COMMUNITY MEETING FORM

Rezoning Petition #2007-045
Community Meeting Notes
May 30, 2007
5:00pm at Freedom Park (Shelter #2)

Re: Rezoning Petition 2007-045

ILLUSTRATIVE SITE PLAN

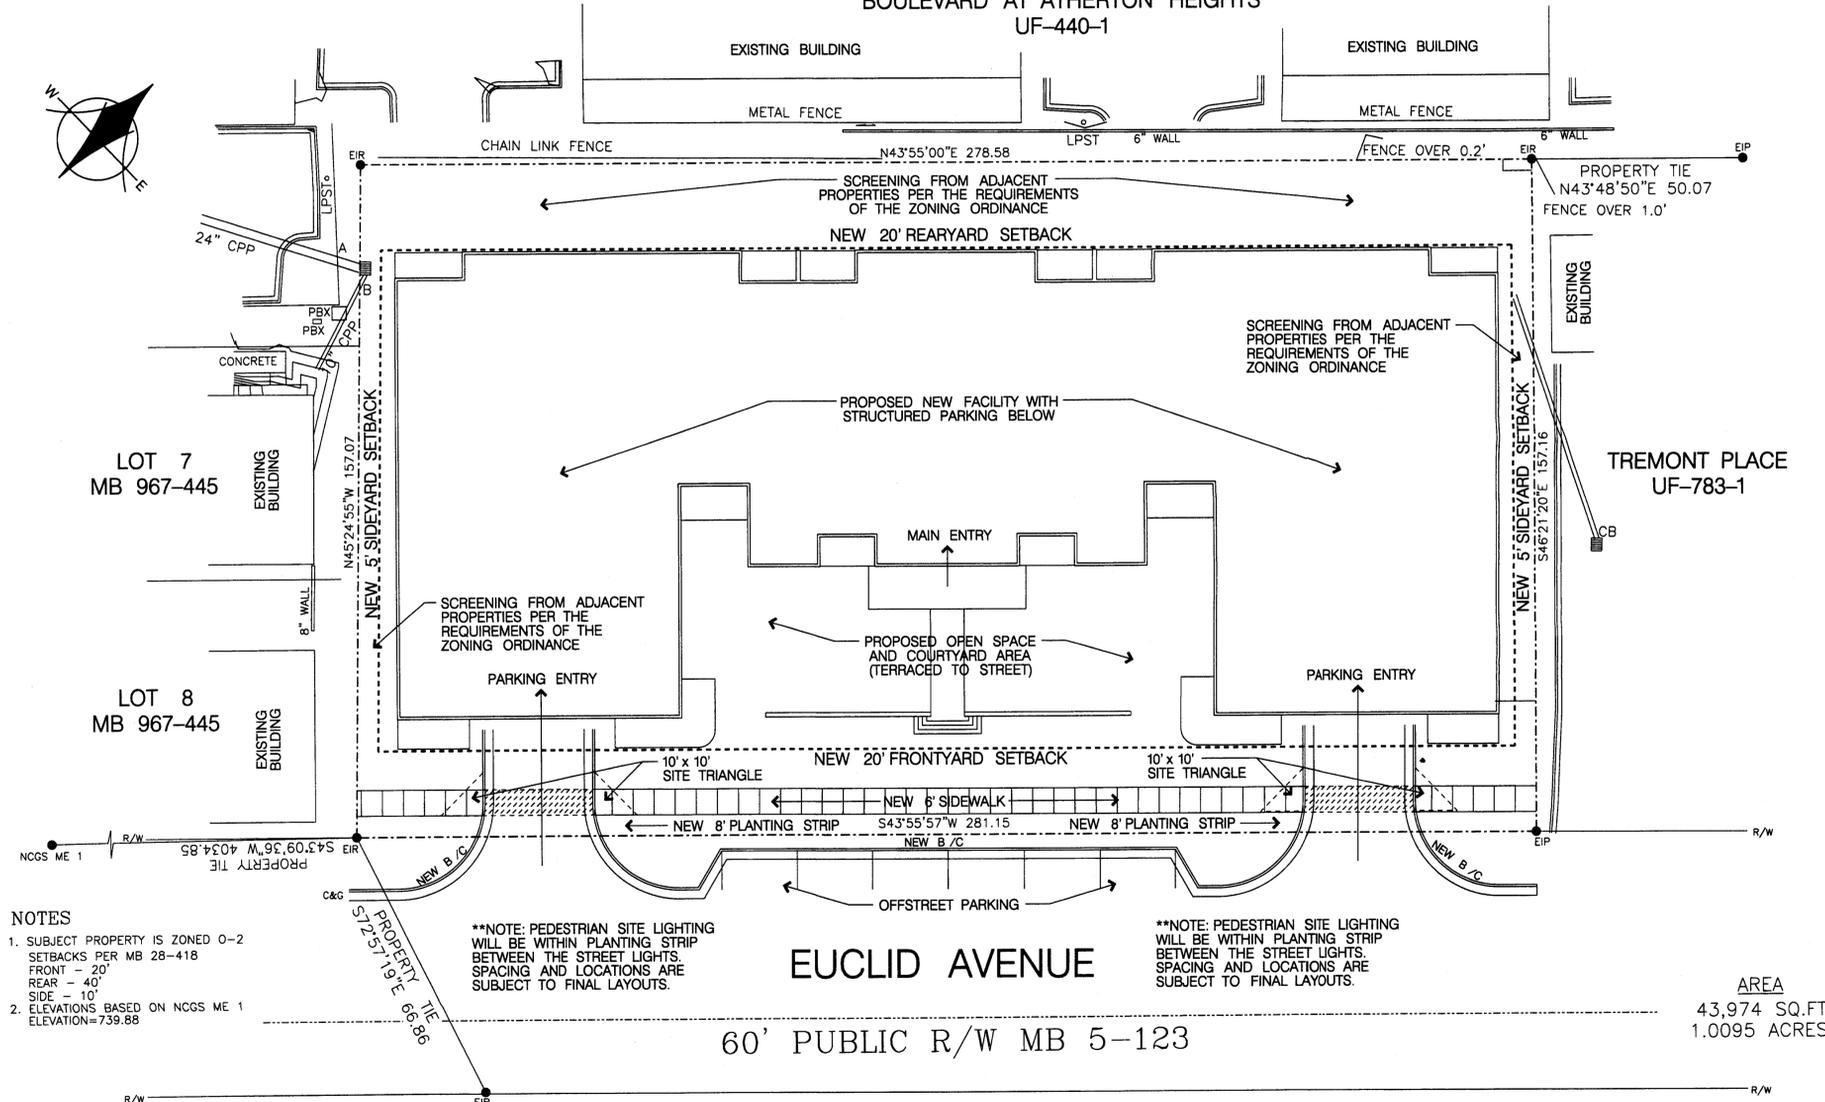
Number of units and mix of unit sizes - Would like to see a reduction in the overall number of units, with more two-bedroom units and less studio units.

Would like to see the building re-designed to incorporate as many front porches addressing the street as possible. Also, due to the topographic nature of the site, the building should be designed in such a way as to step down the hill.

Existing trees were discussed, and the community would like to see that as much of the existing tree canopy as possible will be saved.
3. One neighbor had a concern about infrastructure. Apparently there is a sewage smell at various intersections around the neighborhood, and the concern was that the water would be safe, and that the water pressure would not change.
4. At the end of the meeting we agreed to look at a re-design of the project to incorporate as many of these design changes as possible, at which time we would re-present the project.
